Response to Planning application from Hertfordshire County Council (T and CP GDP Order 2015)

District ref: 6/2020/1325/FULL
HCC ref: WH/2359/2020
HCC received: 24 June 2020
Area manager: Alan Story
Case officer: Paul Marshall

LAND ADJACENT TO 48 THE RIDGEWAY CUFFLEY POTTERS BAR EN6 4BA

Erection of detached dwelling and new vehicular access

Site Plan 1:500 Scale

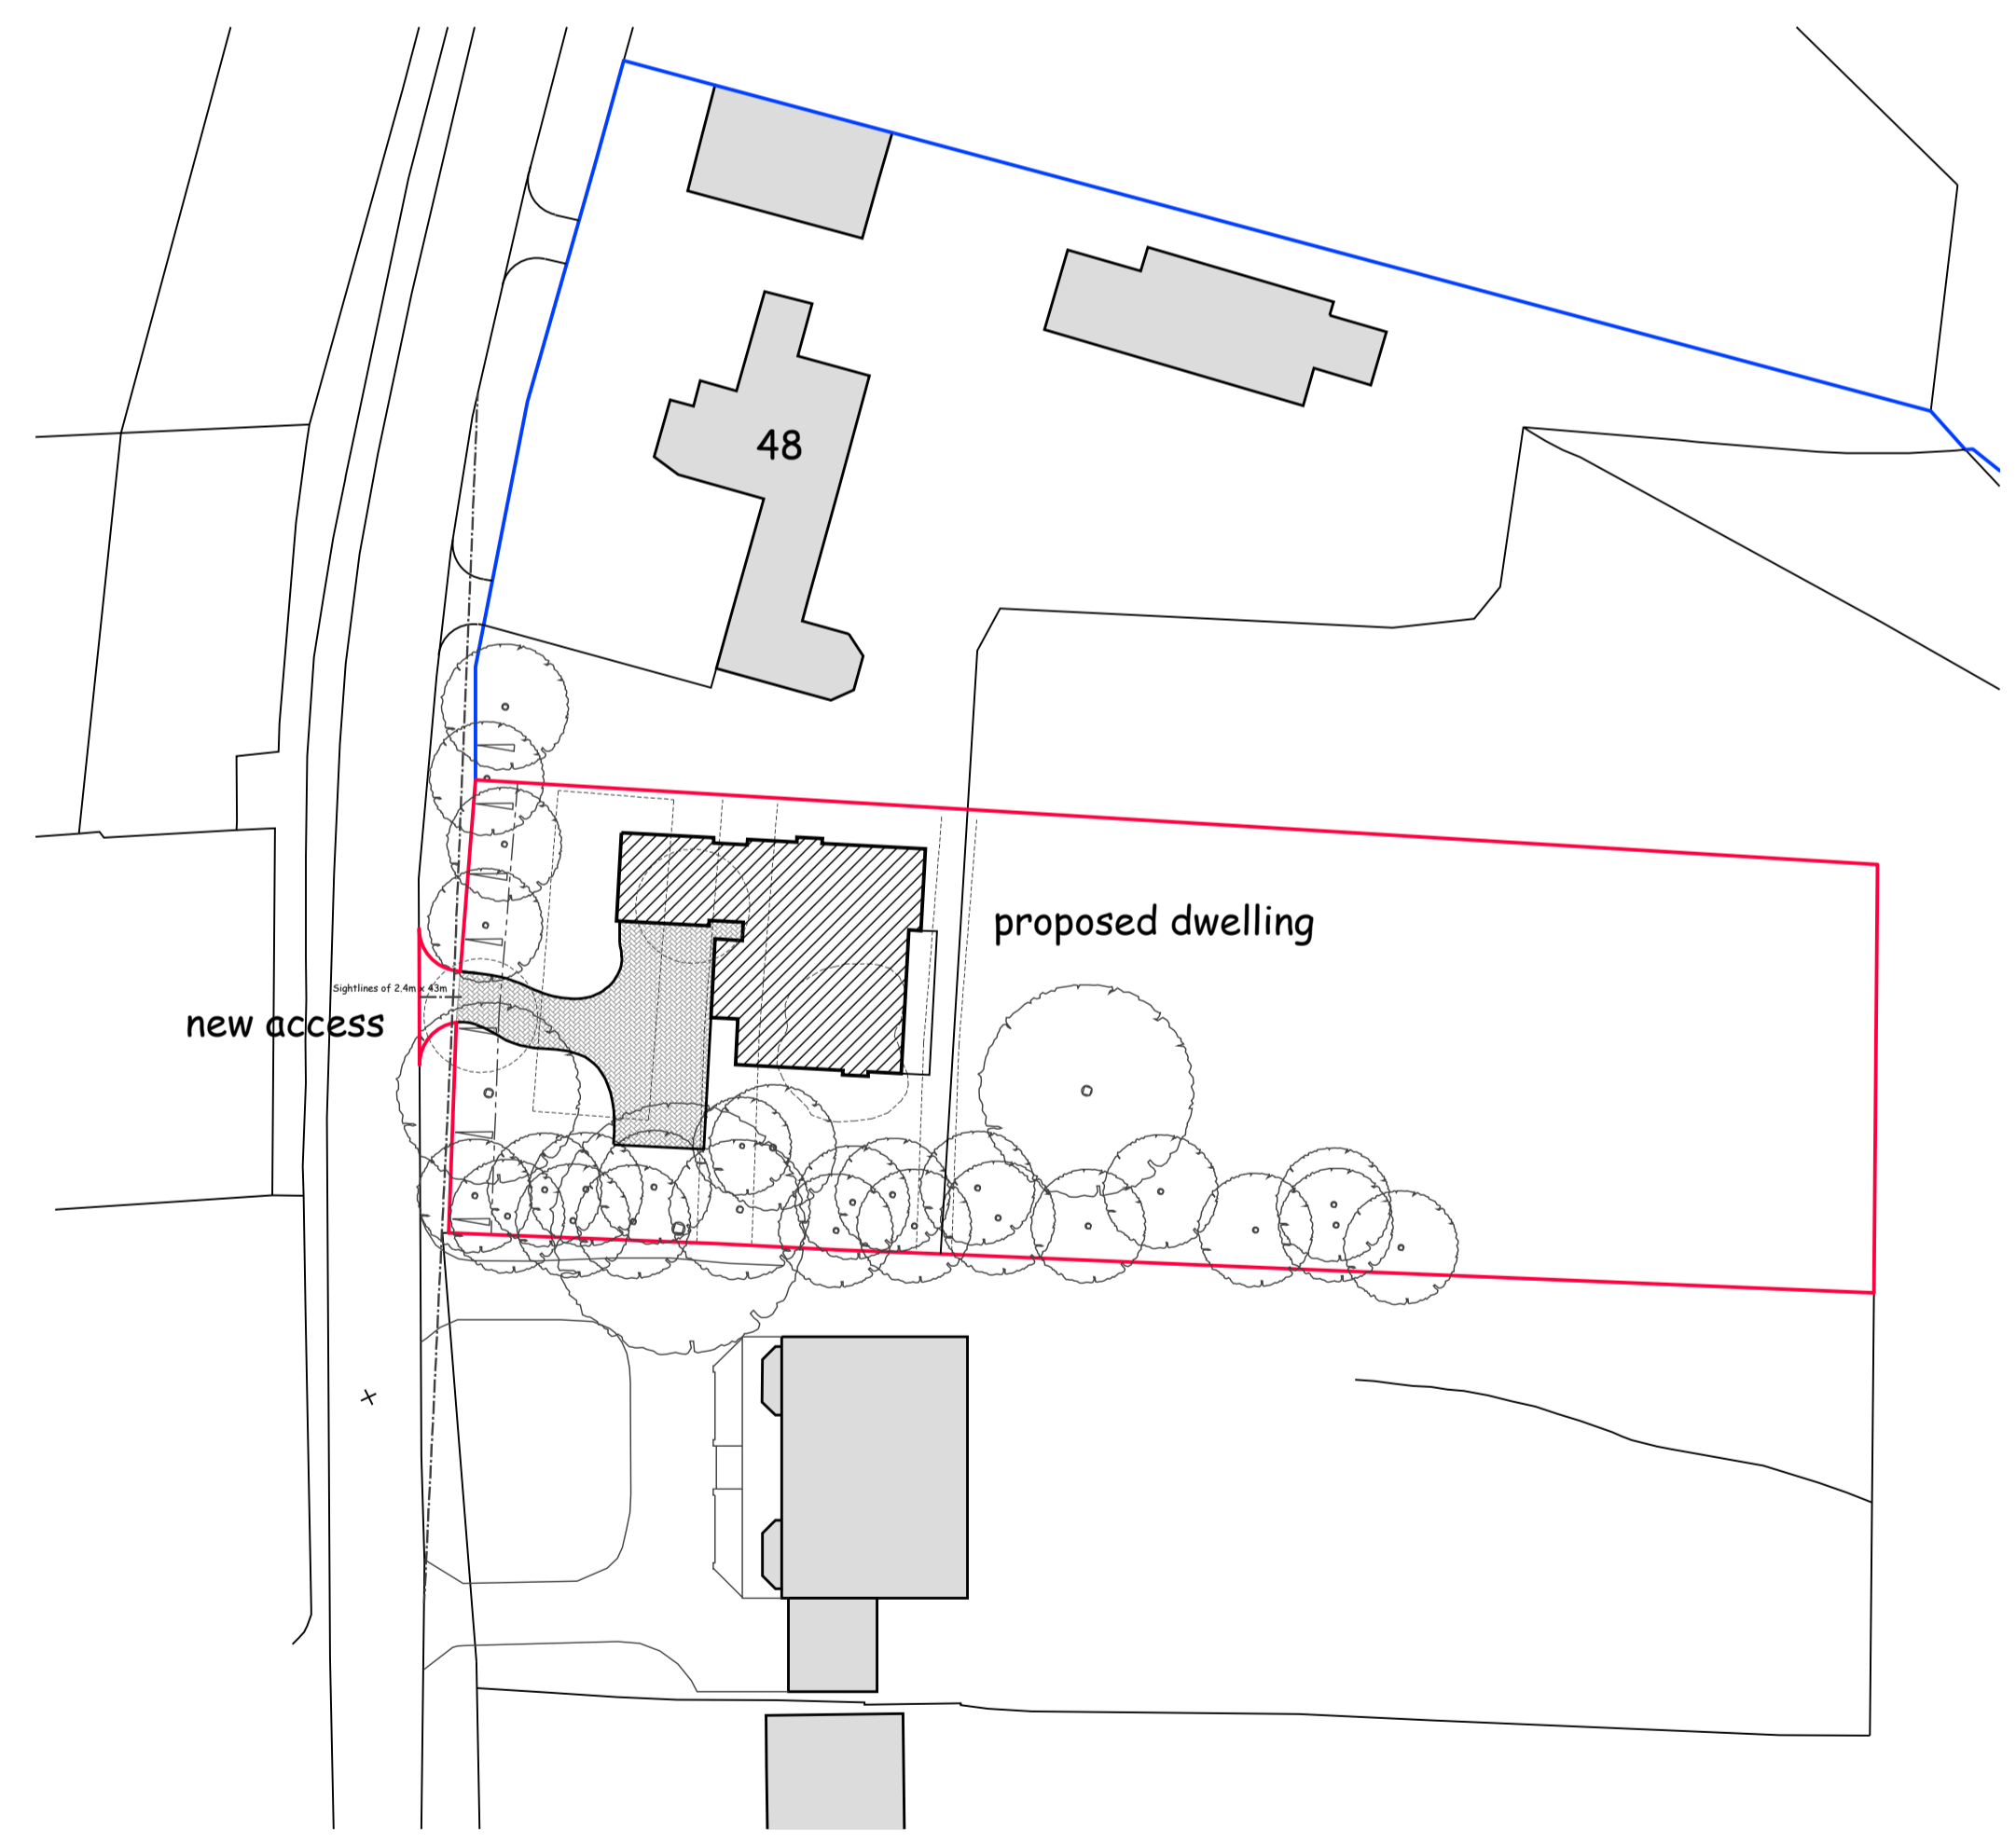
Drawing(1395-P002-A) demonstrates there is space for vehicles to park and enter and exit the site in a forward gear. The double garage is in accordance with Manual for Streets 8.2.3. Hertfordshire County Council Local Transport Plan 4 section 5 states 'all new development provide facilities for charging plug-in and other Ultra Low Emission vehicles. Section 20 (b) states, 'Addressing any barriers to and supporting the uptake of ULEVs in the county. In respect of these proposals I see no reason why an EVC should not be provided. Please see condition 3 above.

Drawing (1395-P002-A) demonstrates a new access onto the Ridgeway. This would need to be in accordance with HCC's 'Residential Dropped Kerbs: Terms and Conditions' and the applicant will need to apply for permission and enter into a vehicle crossover agreement with HCC as the Highway Authority. The maximum width allowable is 5.4m for a double crossover.

CO1) Prior to the first occupation of the development hereby permitted the vehicular access shall be provided and thereafter retained at the position shown on the approved plan drawing number (1395-P002-A). Arrangement shall be made for surface water drainage to be intercepted and disposed of separately so that it does not discharge from or onto the highway carriageway. Reason: To ensure satisfactory access into the site and avoid carriage of extraneous material or surface water from or onto the highway in accordance with Policy 5 of Hertfordshire's Local Transport Plan (adopted 2018).

CON2) The gradient of the vehicular access shall not exceed 1:10 for the first 5 metres into the site as measured from the near channel edge of the adjacent carriageway.
